February 23, 2026

Re: ESC Plan for Carlisle Blvd. & Menaul Blvd. Commercial Development Subdivision, 3535
Menaul Blvd NE - H16E083F - NMR1007QA - (SWQ-2026-00012)

E2RC thanks you for your correspondence and comments regarding the Carlisle Blvd. & Menaul Blvd. Commercial Development Subdivision project. This letter responds to each comment in your letter.

CARLISLE BLVD. & MENAUL BLVD.
COMMERCIAL DEVELOPMENT
COA STANDARD ESC NOTES

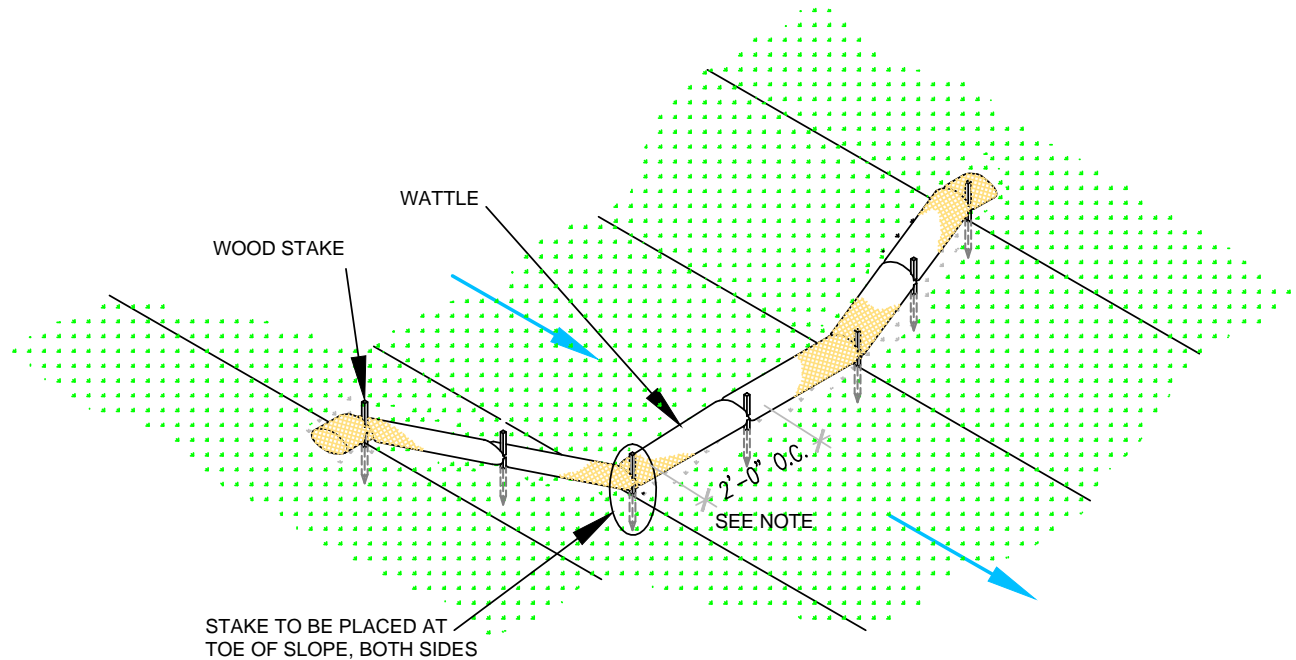
4. Page 4 reflects the February 2, 2026, City of Albuquerque (COA) standard ESC notes and notes that the COA BMP details referenced are still in 'draft' status as of the engineer's stamp date. However, we did not replace the BMP details included in the first submittal, as the BMP specifications developed by the COA are open to comment and change.

SILT FENCE

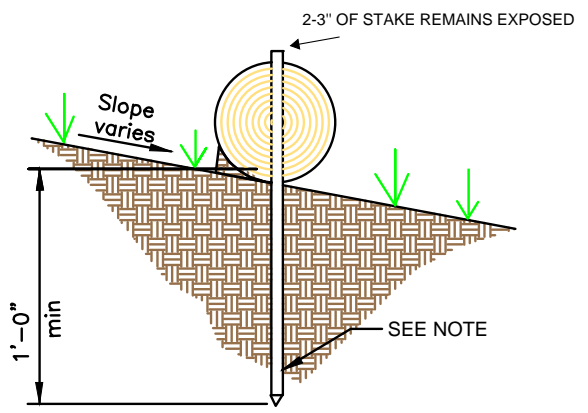
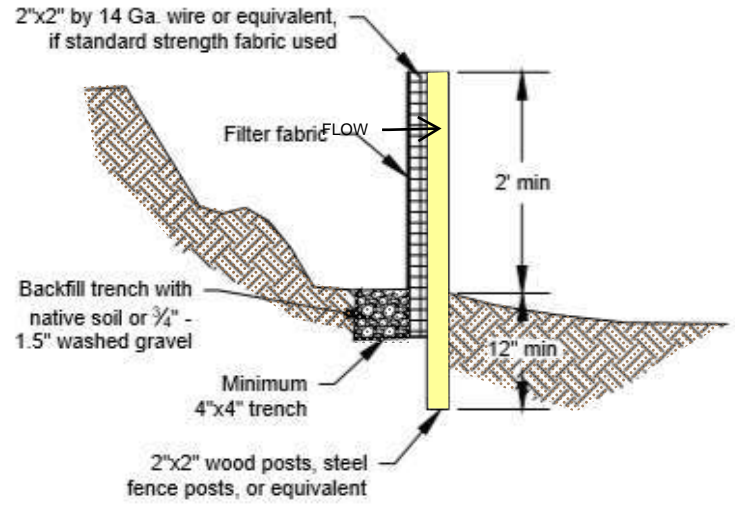
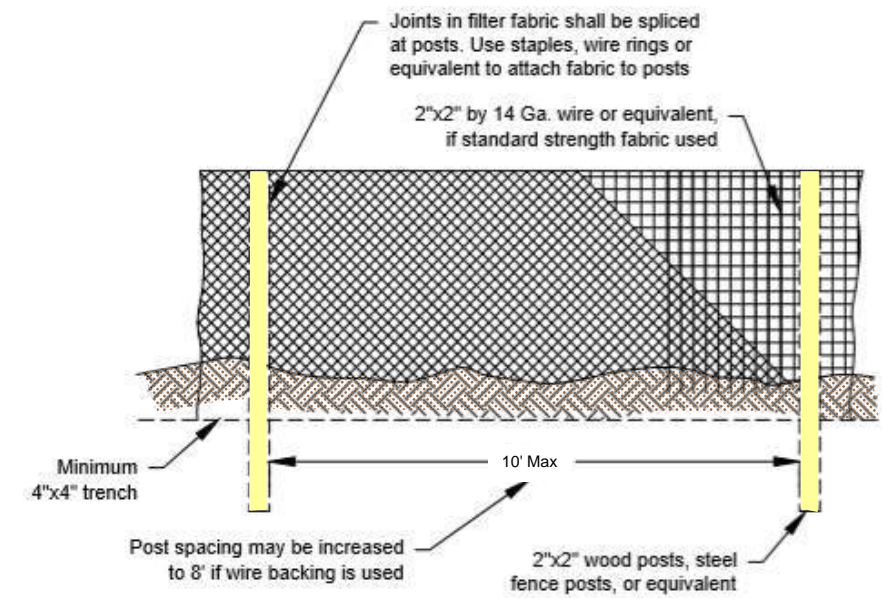
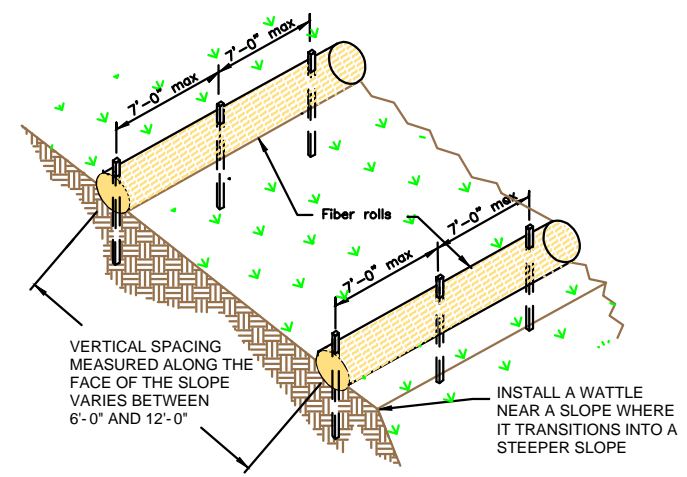
Additionally, the silt fence presently installed was completed under the first submittal which was accepted by COA. Is it COA's expectation that the Operator will remove and replace the silt fence to satisfy a draft BMP detail?

**City of Albuquerque
 Planning Department
 Development Review Services
 HYDROLOGY SECTION
 APPROVED**

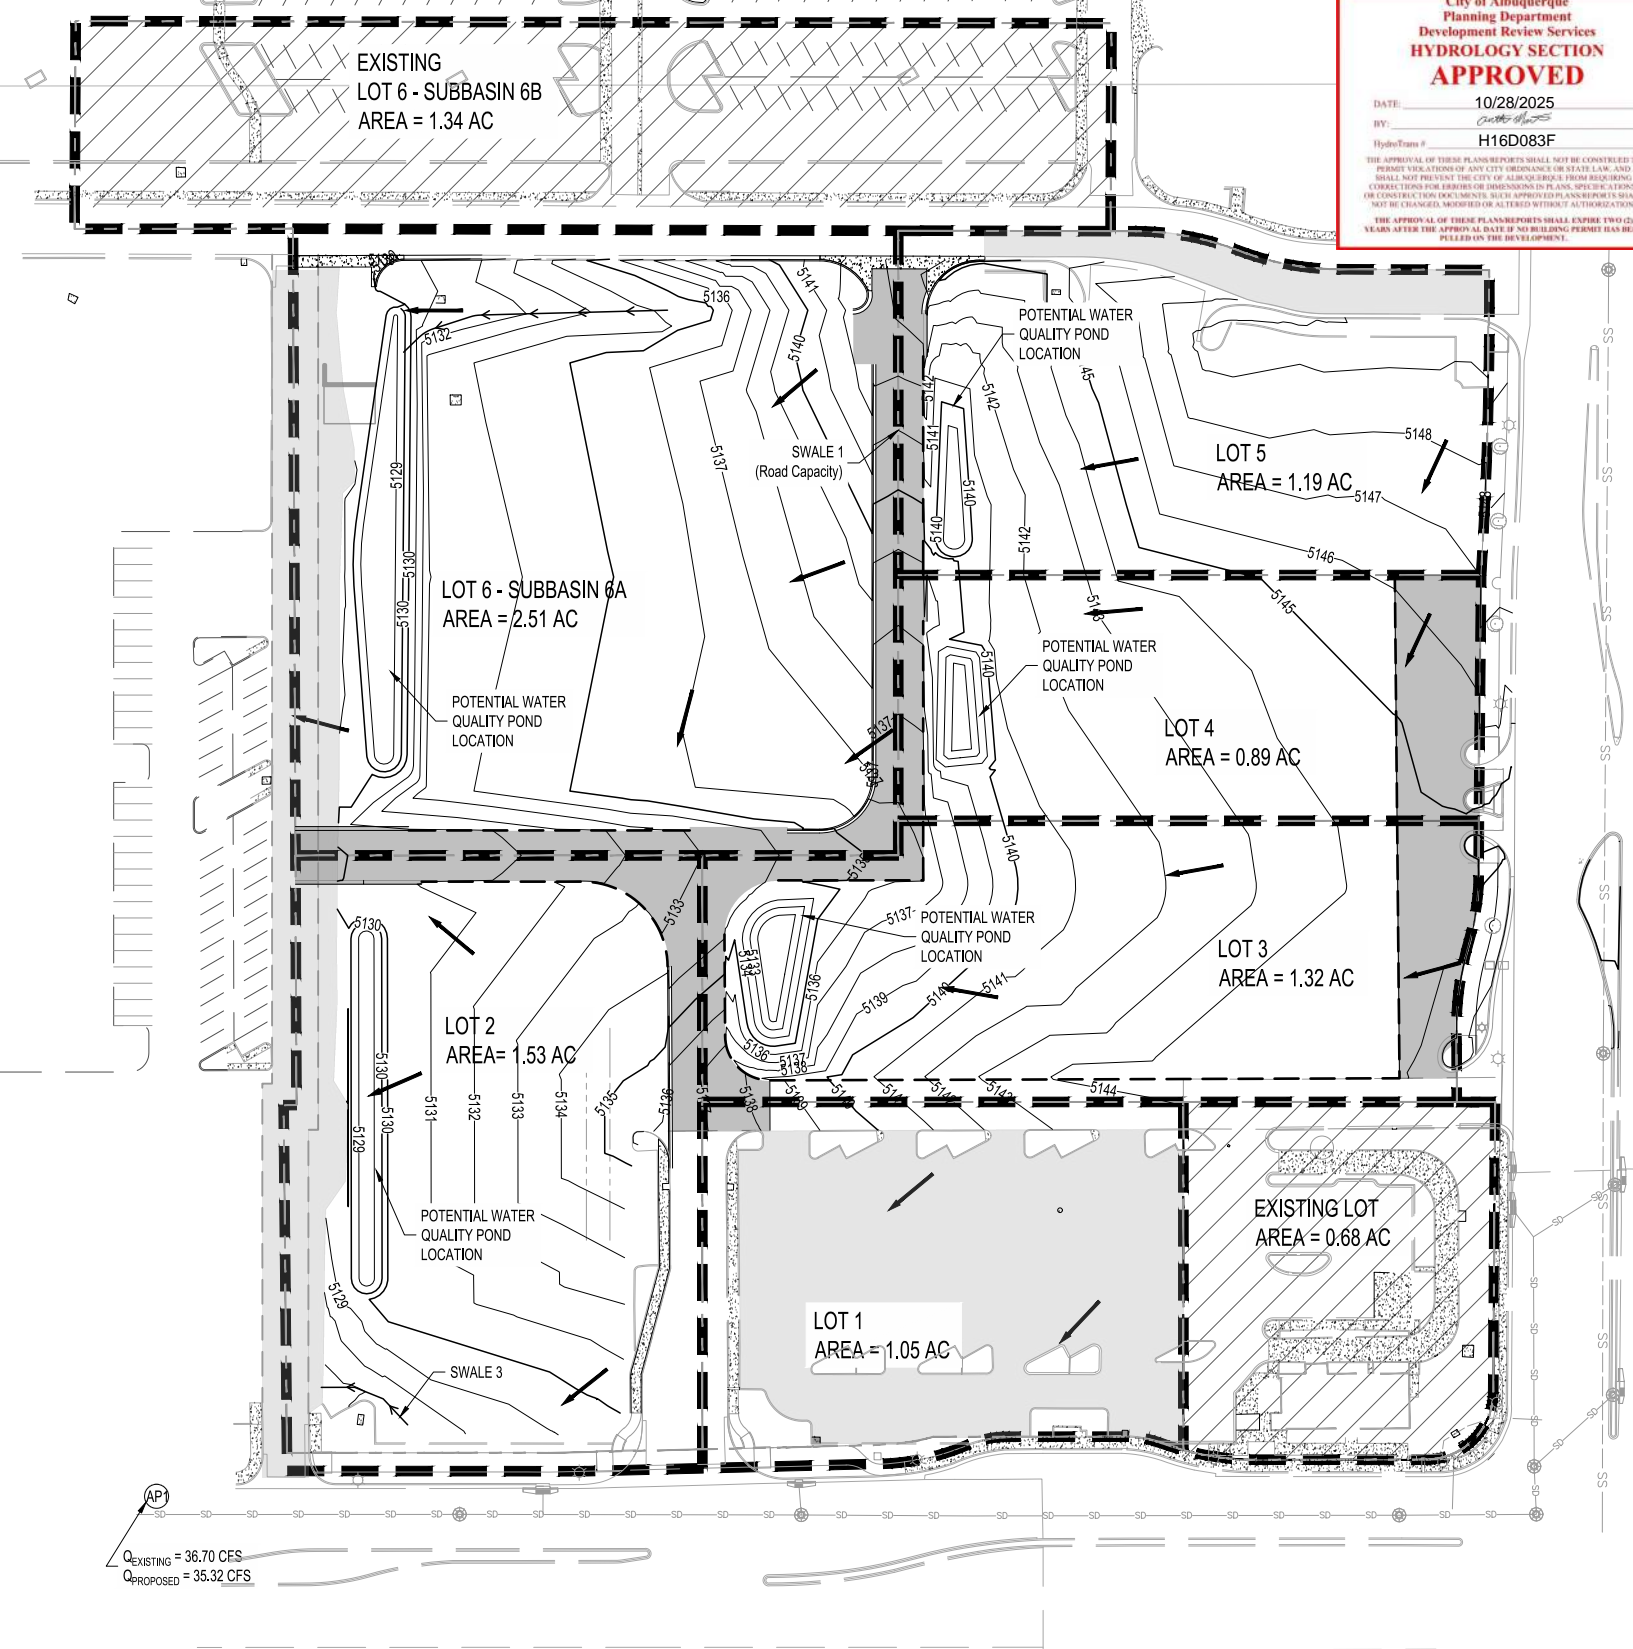
6. The label on Sheet 9 specifies the TESCP is for Phase II. We added a diversion swale on the south side of lots 2-B-3 and 2-B-2 to prevent drainage into the streets on Sheets 9 and 10. Diversion channels to prevent cross-lot drainage should be executed by the prospective buyers' prior to construction as part of the individual lot ESC plans. The *Temporary Diversion Channel* detail drafted by COA is still 'draft' and open to both comment and change. The earthen swale installation detail which was approved by COA Hydrology as part of the *Overall Grading Plan* is included on Page 9.
